**Notice of Exhibition of application for Intercontinental Hotel (former Treasury Building) of SSD project – Stage 2 (SSD 10454)**

Thank you for your referral dated 2 September 2020 inviting comments from the Heritage Council of NSW on the above State Significant Development (SSD) proposal. The proposed SSD site includes the State Heritage Register Item *Intercontinental Hotel Former Treasury Buildings* (SHR no. 00355). The site is also located in the vicinity of several other State listed items.

**Steven Meredith**  
Regional Manager, South  
Heritage NSW  
Department of Premier and Cabinet  
**As Delegate of the Heritage Council of NSW**  
29 September 2020

5 3D VIEW - L07 ARCADE BALUSTRADE REPLACEMENT

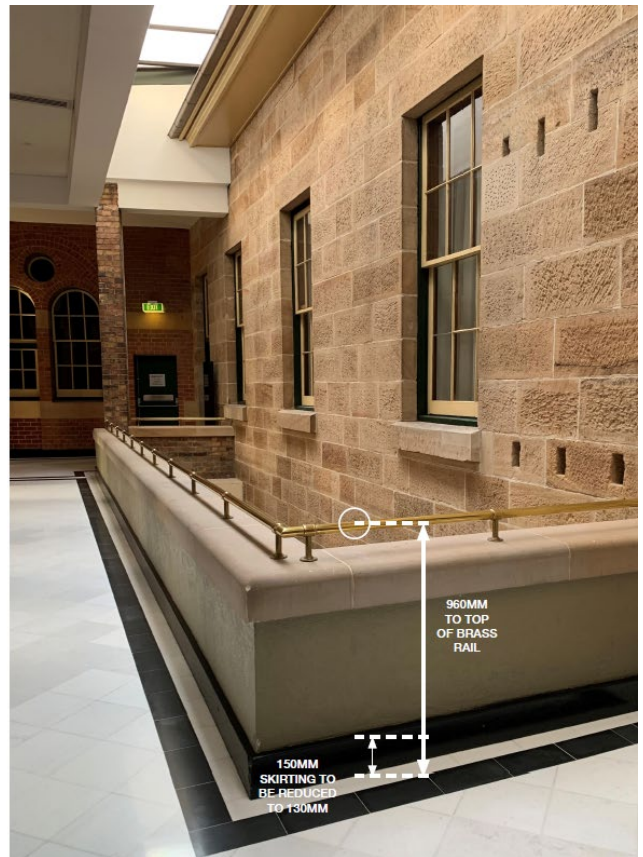
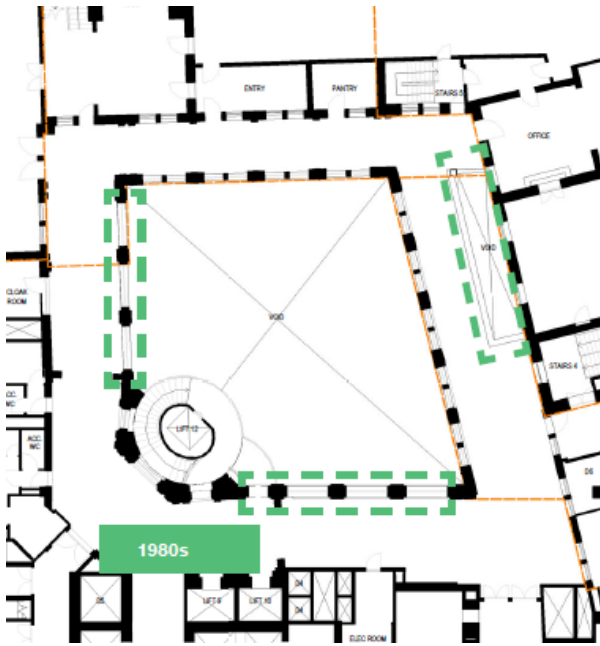
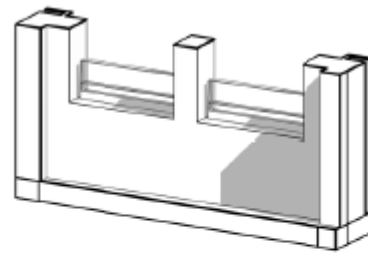
- The design of the handrail located on Level 7 should be reconsidered to be more recessive. While the handrail may have limited visibility from the cortile space below, the extended use of the handrail along the voids may have a high visual impact. The proposed section of the handrail includes a heavy base that may dominate the visual aesthetic of the sandstone coping.
